From: Martyn White
Sent: 14 December 2018 12:05
To: Planning.Responses
Cc: Simon Davis
Subject: FW: BR/214/18/PL

BR/214/18/PL

The application is for a terrace of four houses which would front on to West Street. The site is part of the former tennis court to the Royal Norfolk (a listed building) and is located within the Waterloo Square and the Steyne conservation area. Further, there are a number of listed and locally listed buildings in the local area. Development in this location therefore has the potential to affect the setting of a listed building, but also the character of the conservation area.

Drg No: **RNHB.PLAN 2**

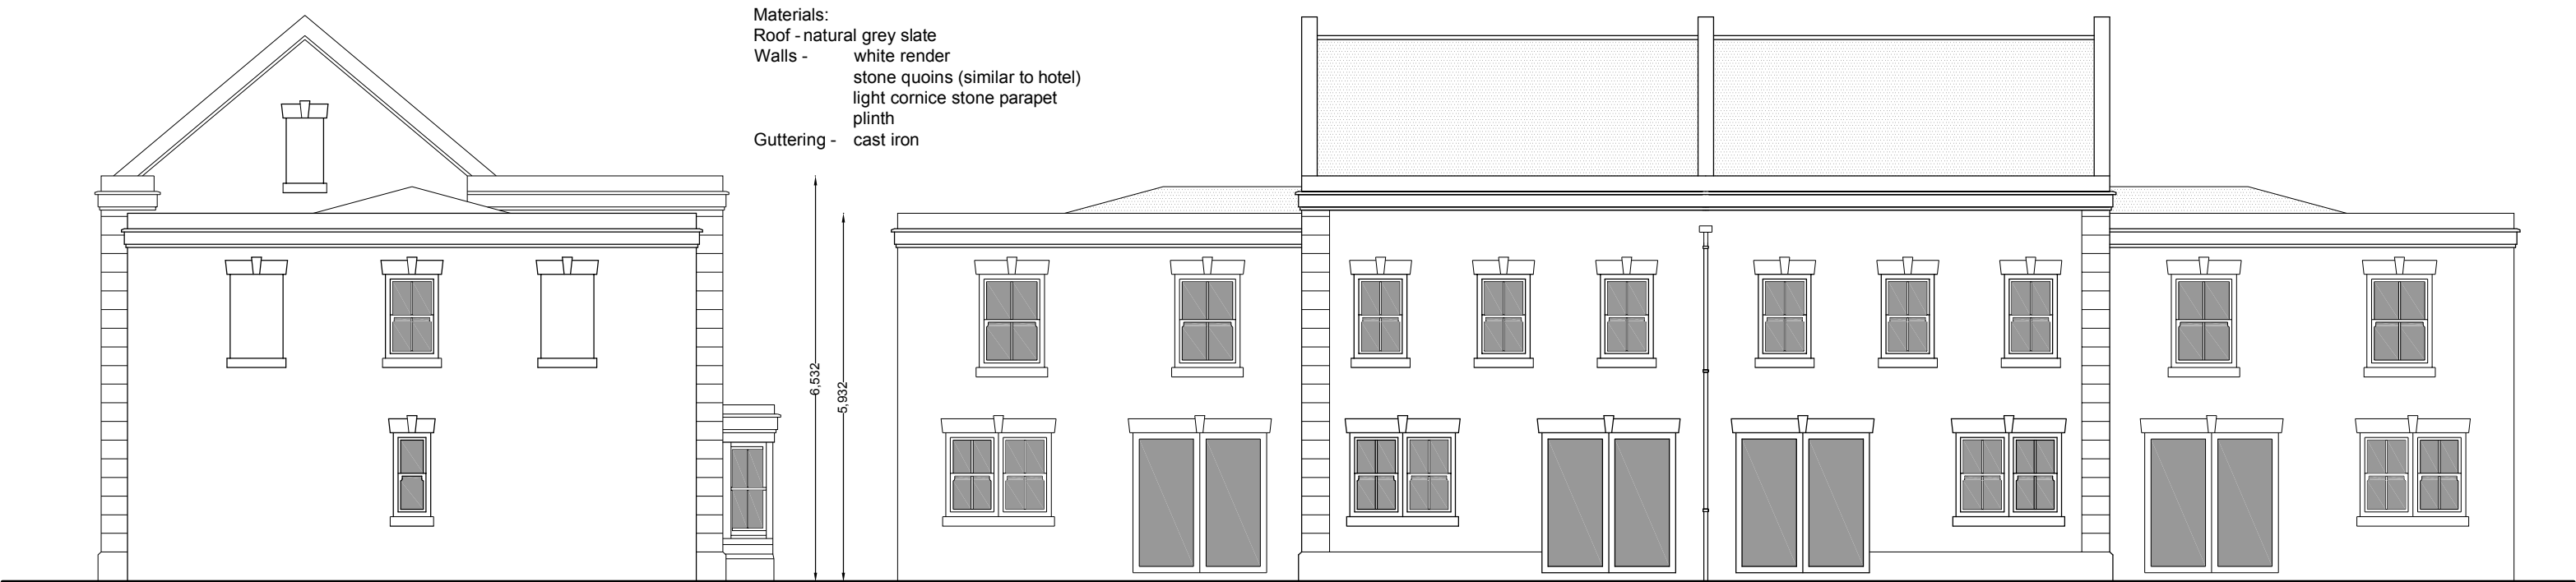
I also note from looking at the drawing which identifies the view of the front elevation from West Street, that the roof of the central two buildings would not be seen. This is in contrast to the second elevation 'view from south' which indicates that the second blue sight line would see the roof. Which is correct?

The design of the terrace is such that the middle two units would include a roof terrace. Such a feature would introduce an additional area of amenity space for use by the residents. It is considered that such a feature is not prominent in the local area, and would be in contrast to the established character. It is considered that the roof terraces would introduce further clutter in the form of garden furniture etc. which would be visually distracting, and inappropriate.

Drg No: **RNHB.PLAN 3**

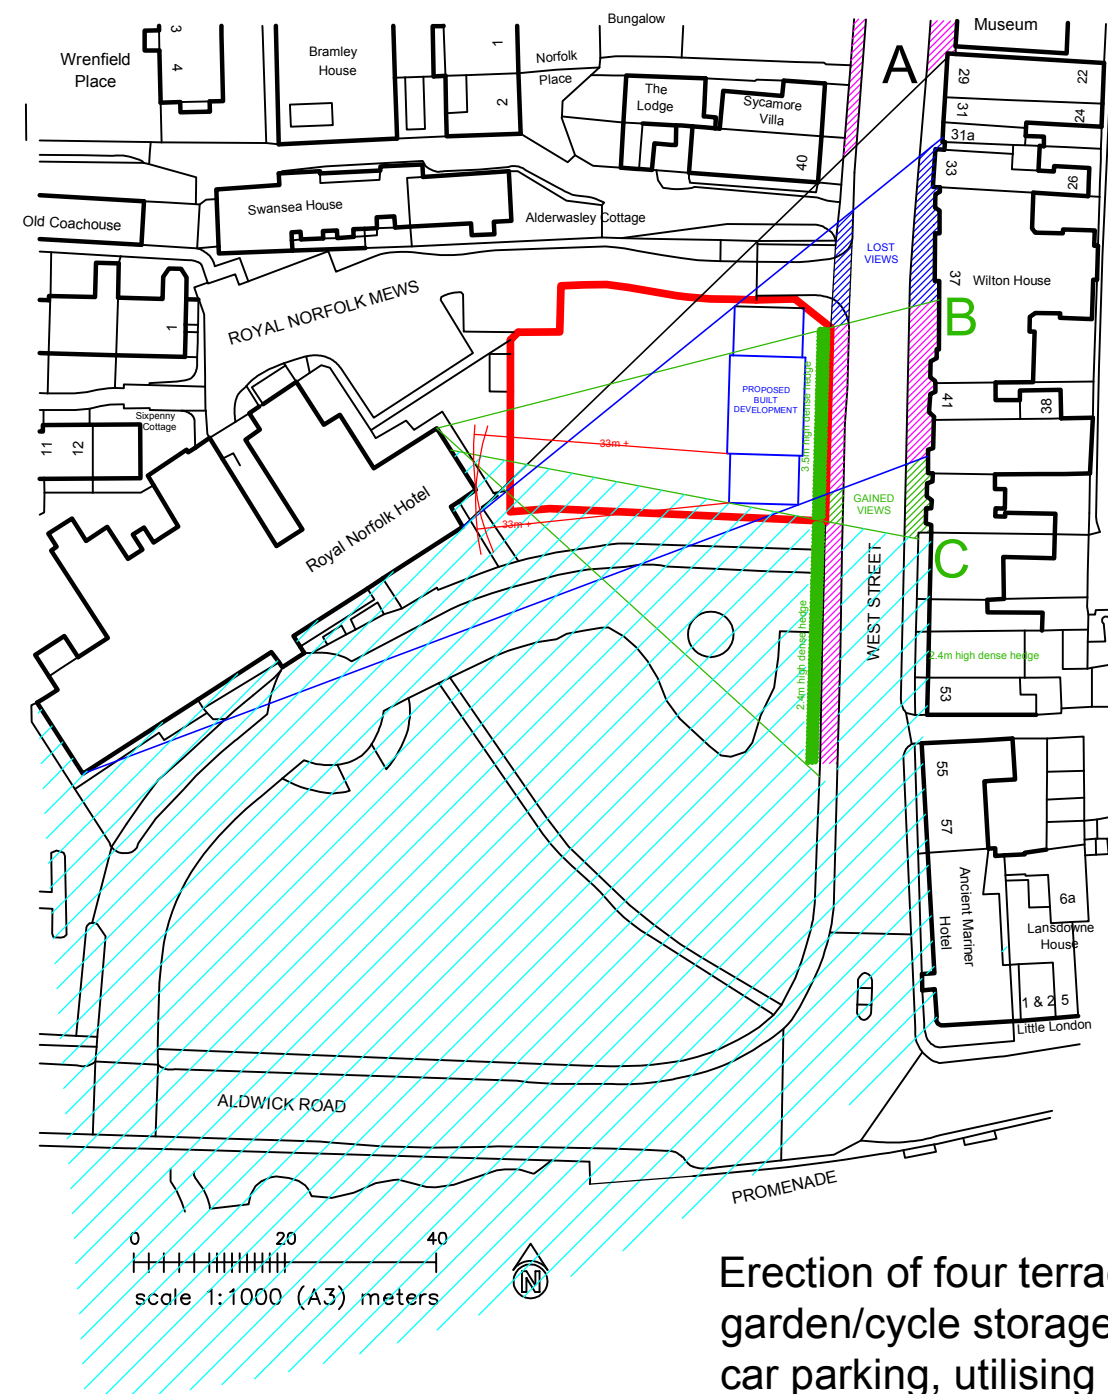
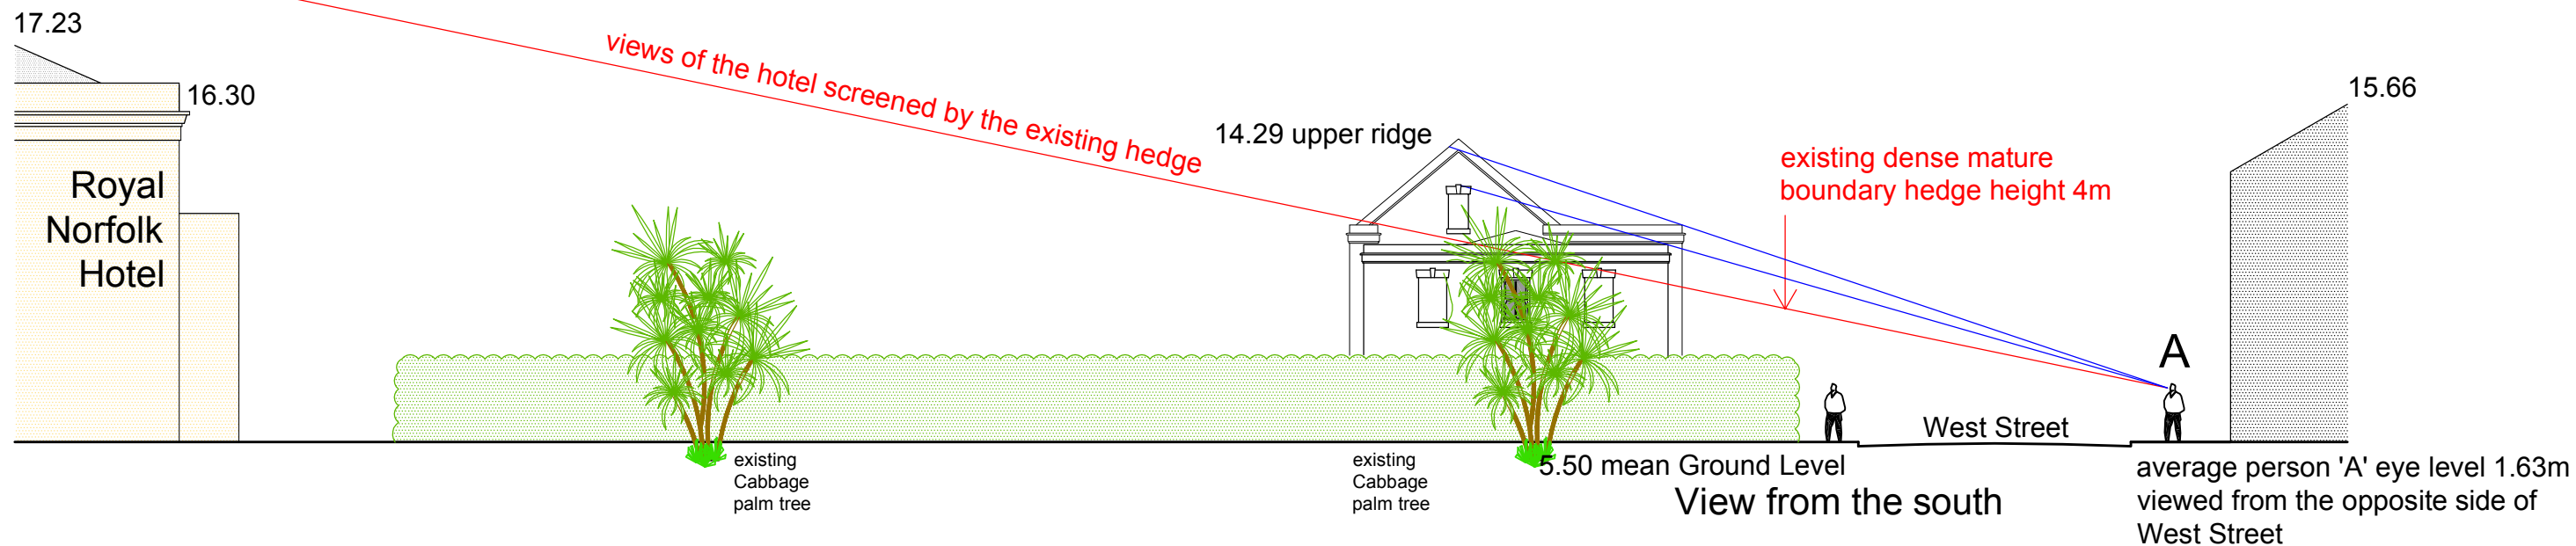
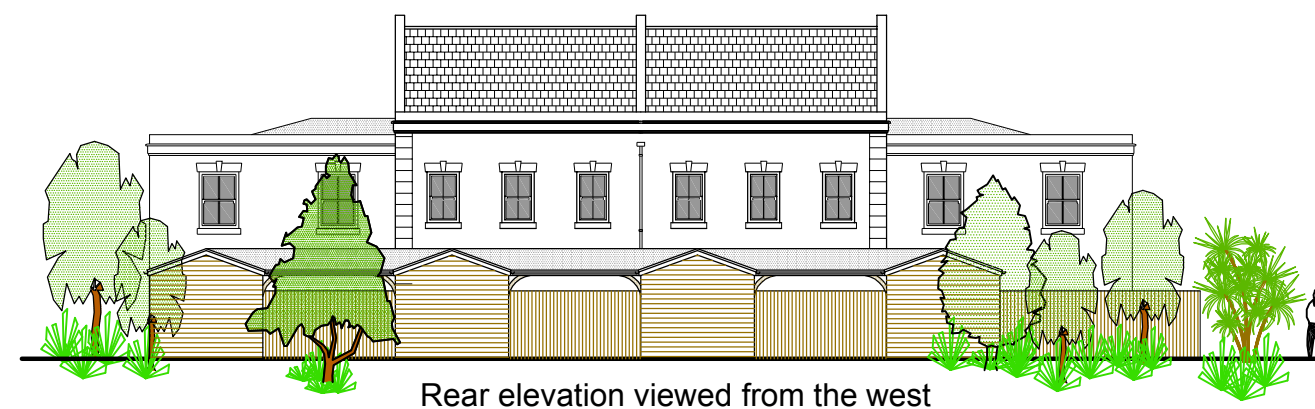
The proposed terrace would continue development further towards the seafront in a location which does not appear to have had development before. Further, it would erode the space around the listed building, and harm the established character of the area.

The terrace of houses would be located in close proximity to the listed building and even with the hedge screening on the southern boundary would be read in the context of the listed building.
